City of Portland
Development Review Application
Planning Division Transmittal Form

Application Number: 2014-033 **Application Date:** 04/02/2014
CBL: 197 B018001 **Application Type:** Level III Site Plan 50,000 - 100,000
Applicant: CHARTER WESTGATE LLC /Karen Johnson
Project Name: Dunkin Donuts
Address: 1412 CONGRESS ST
Project Description: Reuse of former Tim Horton's restaurant for a proposed Dunkin Donuts.
Zoning: B2

To: FILE
From: Jean Fraser
Subject: Application ID: 2014-033
Date: 4/10/2014

Comments Submitted by: Marge Schmuckal/Zoning on 4/10/2014

1 SCHEMATIC SITE PLAN
 A0.2 SCALE: 1/4" = 1'-0"

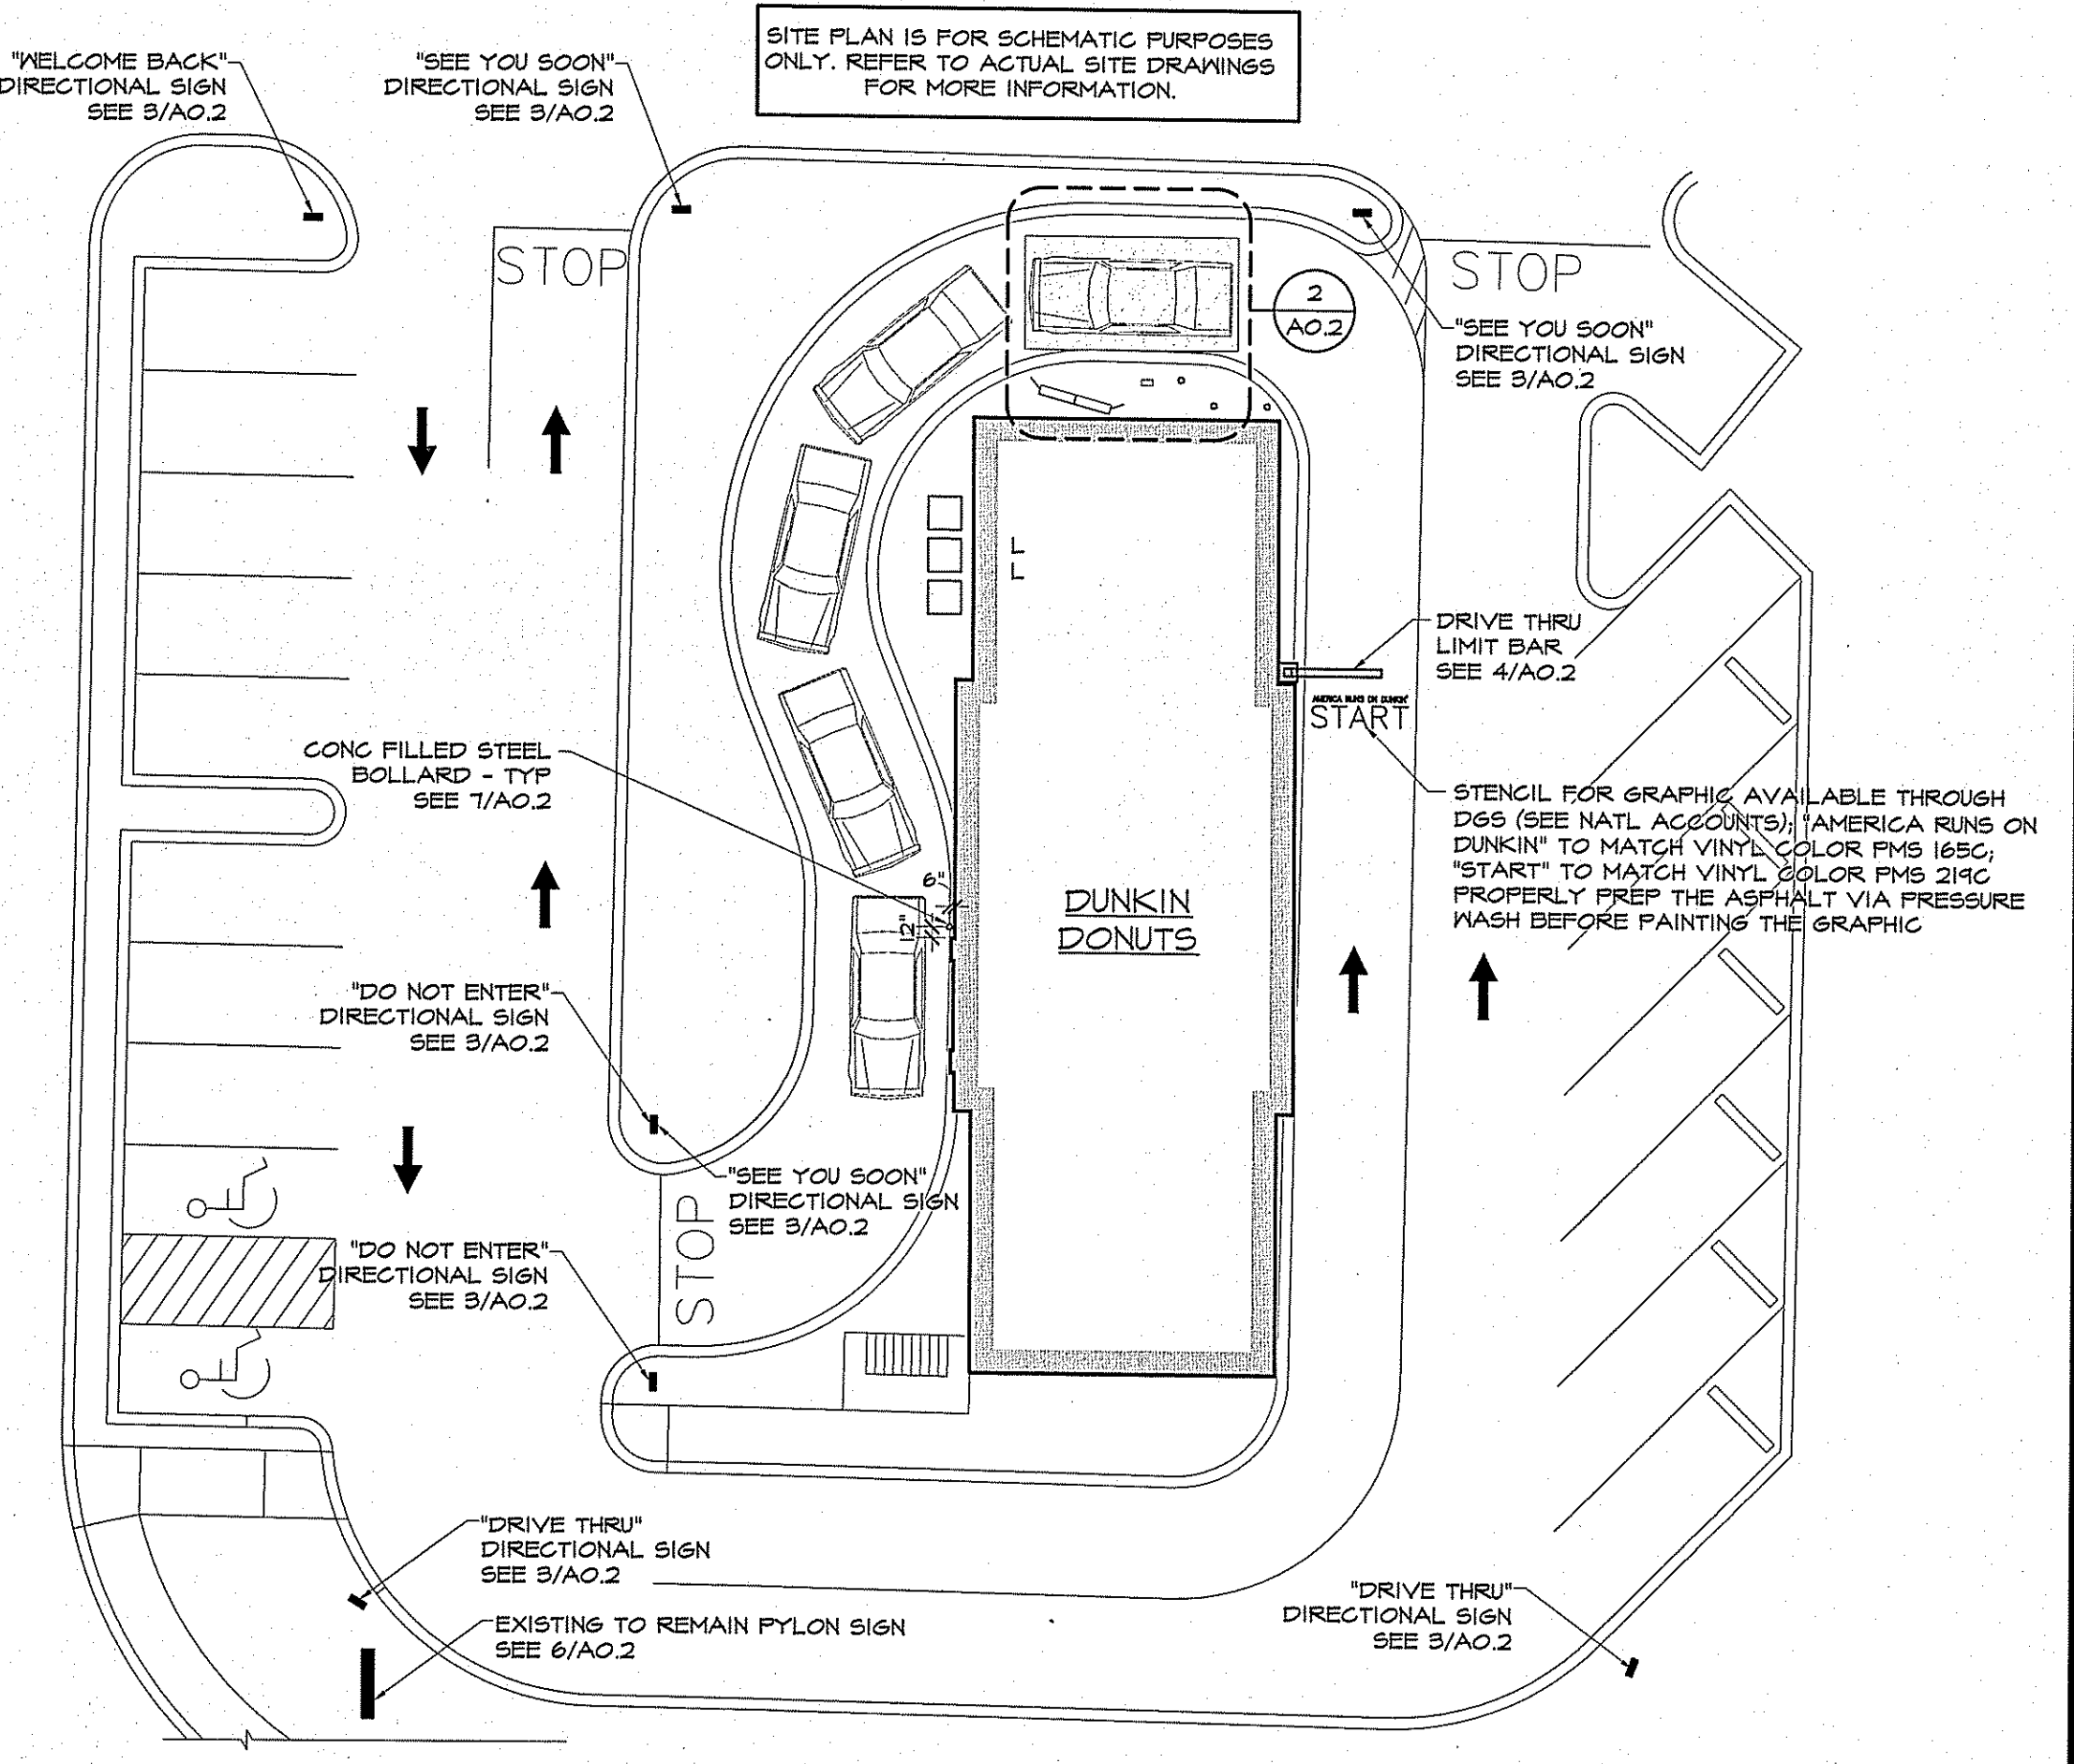
Section 14-183(a)6(a) specifically states within the text: "In addition, drive-through features shall not extend nearer than twenty-five (25) feet to the street line." There has been some concern as to where the measurement to the street line actually is located. The definition of "street line" is located in 14-47 and states: "Street line: the line of demarcation between a street and the abutting land." This definition does not use the terminology of abutting property line. Therefore I interpret the street line definition to mean the demarcation between the street pavement and the abutting land and not an abutting property line. The curb would be the specific transition point between the street and the abutting land.

Also, do I understand your email and this drawing to mean that the 25' setback will not be met if we measure from the edge of the ROW rather than the travel portion?

They can not meet the 25 ft setback requirement with stacking along the front if the 25 feet is measured from the property line- that line is shown on the attached which they submitted originally. They would have to ask for a variance from the ZBA in this case.

Coincidentally, if the "streetline" is as shown on the plan submitted today (ie at back of the traveled way, not at the back of the sidewalk) then they can squeeze the stacking lane in along the front and just meet the 25 ft setback. I agree their plan is not very precise, but based on my quick GIS measurements I think its 99% likely.

So this is a fundamental issue and Marge's interpretation needs to be confirmed.
